Our reference: P-589671-B5X5
Contact: Sandra Fagan
Telephone: (02) 4732 7992

11 December 2023

**Council Response to Environmental Impact Statement - SSD-30871587
– Warehouse and Distribution Centre at 805–817 & Part 799–803 Mamre
Road, Kemps Creek, NSW, 2178**

TYPICAL SECTION - OPEN SPACE EDGE ROAD (BY OTHERS)  
SCALE 1:50

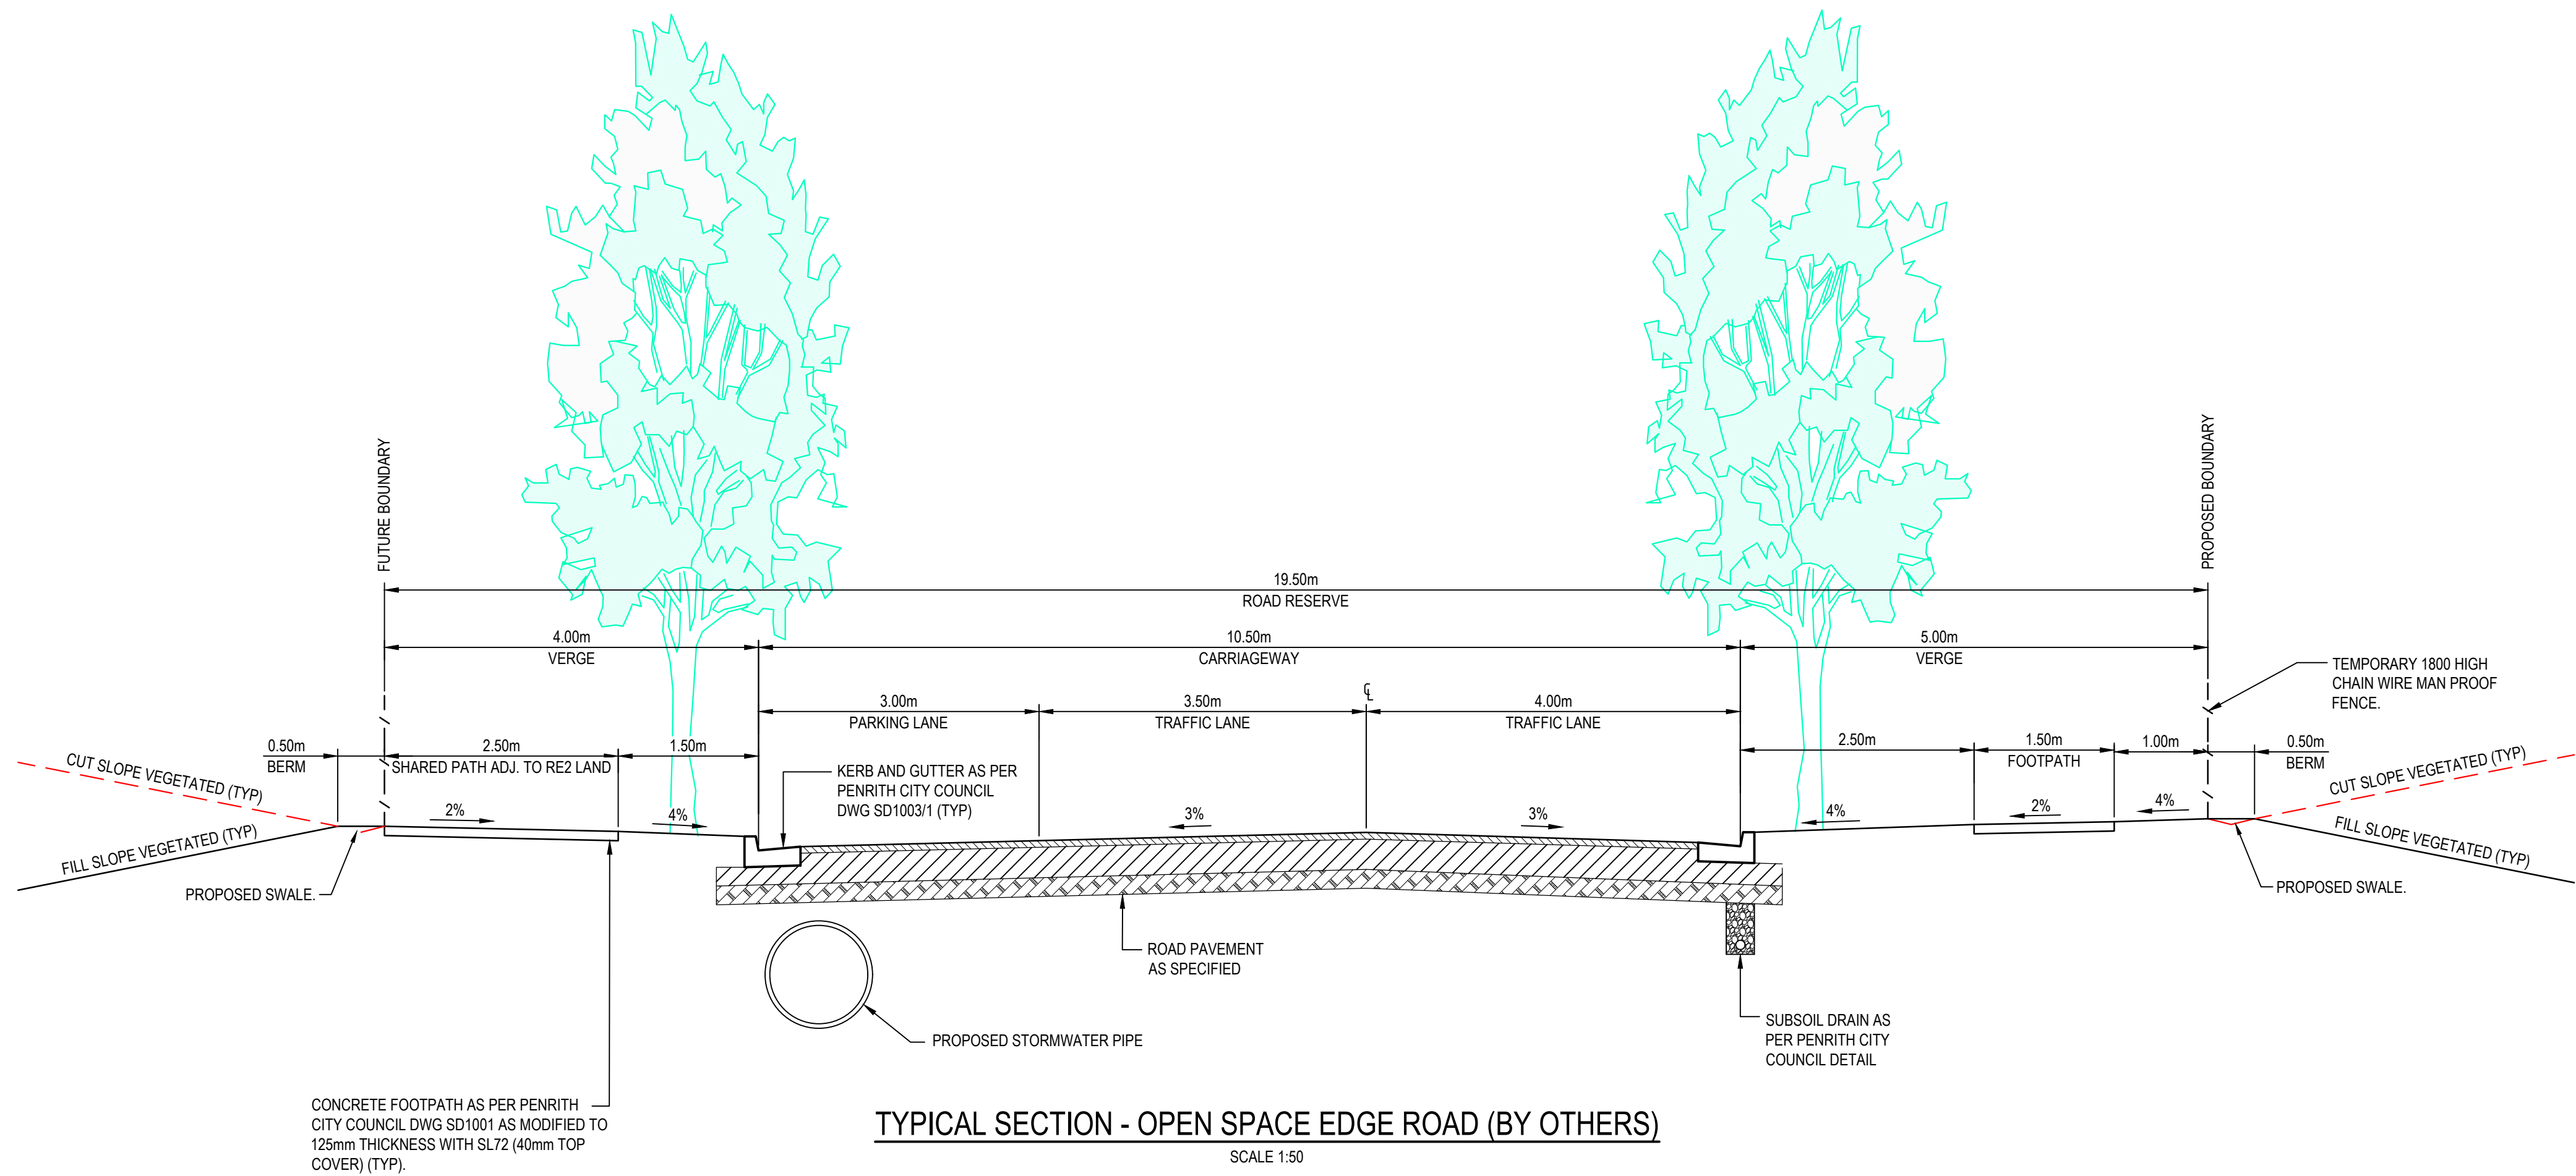
- a) DPE are requested to carefully consider the proposed staging and delivery of the Open Space Edge Road. This road is shown in the Mamre Road Precinct DCP (Figure 12) and is an important piece of infrastructure to serve the adjoining open space corridor.

- b) The Open Space Edge Road should be delivered as part of the proposed development and detailed engineering plans provided. The applicant should provide information to support their statement that Council has agreed in principle to the road being delivered by others, possibly through contributions or a Planning Agreement. If a Letter of Offer to enter into a Planning Agreement has been made to Council, the applicant should provide DPE with a letter confirming at least in principle support from Council. (Note that Council's City Planning Team have provided further comments about this at the end of this letter).

realigned to be within the REI zoned land. This position remains given the previous advice by Council staff. If such a realignment is permitted, DPE should be satisfied that the realigned road will suit the future road alignment on adjoining properties and beyond, to result in the full length of the road being realised as per Figure 12 of the DCP.

Project	805 MAMRE ROAD KEMPS CREEK
Title	CONTEXTUAL ROAD LAYOUT PLAN

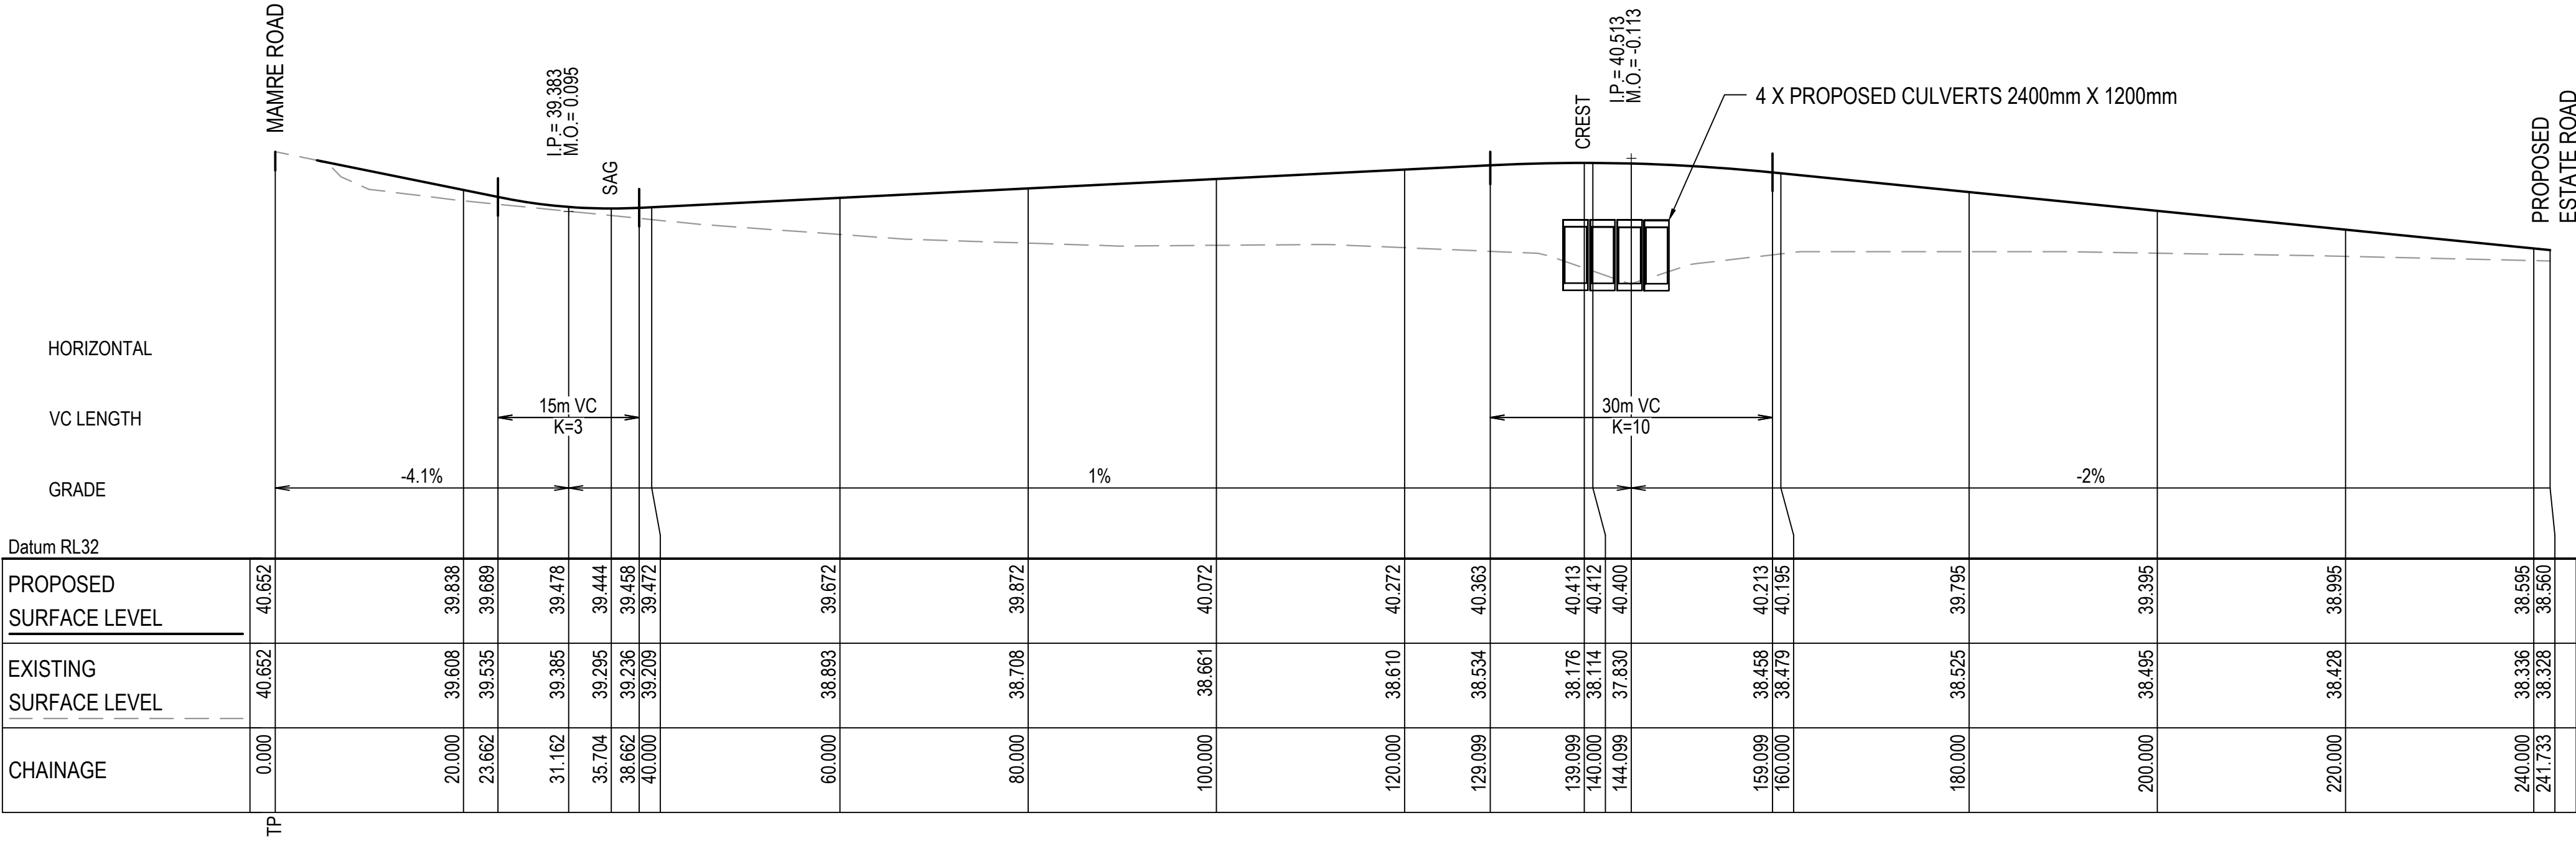
- e) Regarding the local collector road, DPE should be satisfied that this road alignment accords with the DCP structure plan in terms of alignment, location, and width, and will tie in with the adjoining properties as shown in Figure 12 of the DCP.

- a) The long section of the collector industrial road passing through the site is to be extended beyond the property boundaries, to demonstrate future tie-in with the adjoining developments.

PROPOSED RETAINING WALL PLAN - TW01  
1 : 500

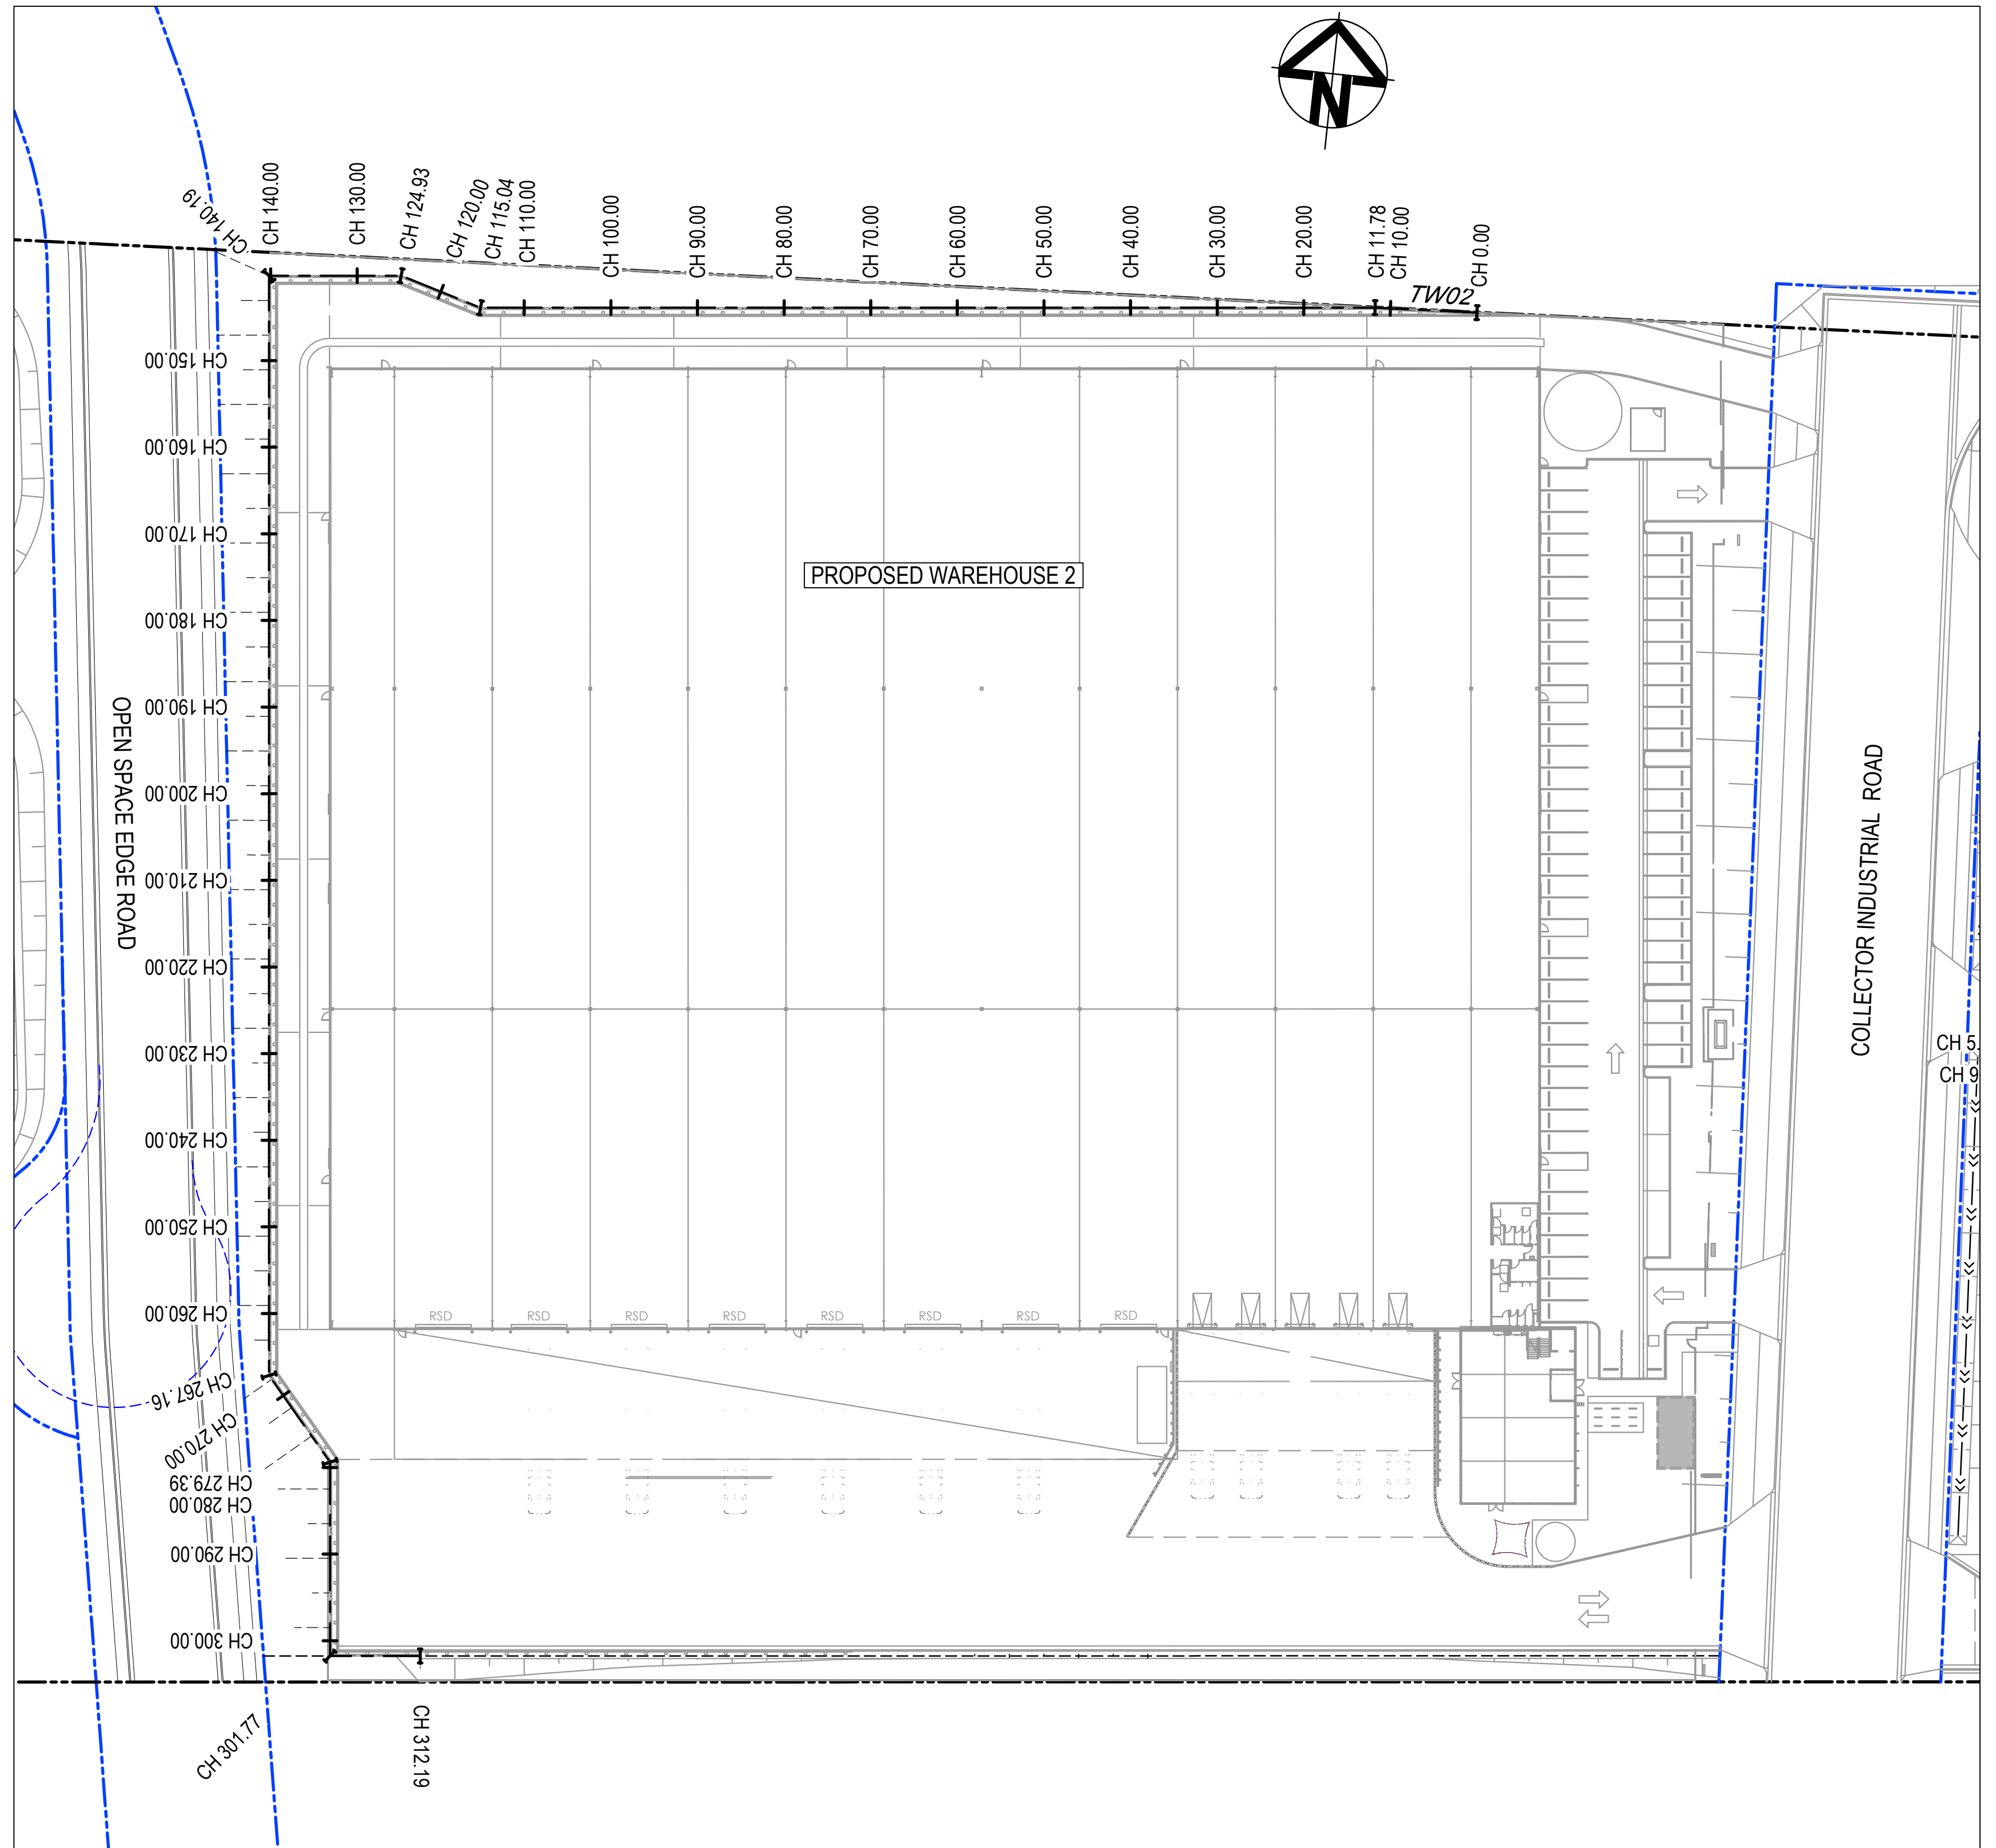
- k) There is a large extent of retaining wall shown around the northern, southern, and western edges of proposed warehouse 2. The western edge is of particular concern as this facade fronts the Open Space Edge Road and adjoining open space beyond. The DCP requires facades along primary street frontages to strengthen passive surveillance and streetscape character. The DCP also requires retaining walls to be no more than 2m in height adjoining public domain/roads.

- l) It appears that warehouse 2 will be above the road and open space levels, requiring extensive lengths of retaining walls and not interacting with the adjoining (future) public road. This is a poor outcome. DPE should consider in the first instance whether this is a satisfactory solution and whether the proposed batter adequately reduces the impacts.

- m) If this proposed arrangement is acceptable to DPE, the consent authority should also be satisfied that the retaining walls remain mostly screened from public view, and that the landscaped setback between the road and the warehouse lot is adequate to provide vegetation to screen the retaining walls. At a preliminary review, the batter (setback) between the wall and the Open Space Edge Road appears inadequate to accommodate suitable screening vegetation. This appears to particularly be the case in the north-west corner of the warehouse 2 lot. In this location, at chainage 140, the proposed retaining wall is about 2.42m high. The position of this section of retaining wall would also be highly visible to (future) passing pedestrians and motorists using the Open Space Edge Road. In addition, the retaining wall at chainage 140.00 (on the corner) is positioned close to the northern boundary which would not allow suitable screen planting. DPE should be satisfied that the proposed tree planting along these edges is realistic, and whether the proposed landscaping is adequate to provide a suitable landscape screen and public road interface. Figure 29, taken from Viewpoint 5, in the Visual Impact Assessment shows the resulting view at both 'Year 0' and 'Year 15'. This demonstrates that the western frontage to the Open Space Edge Road relies heavily on the long-term success of tree growth, rather than the matter being addressed through the design of the building and development.

- n) In addition, as shown in part 6 of the Civil Engineering Report, the retaining wall along the northern boundary adjoining warehouse 2 encroaches upon the 2m side setback.
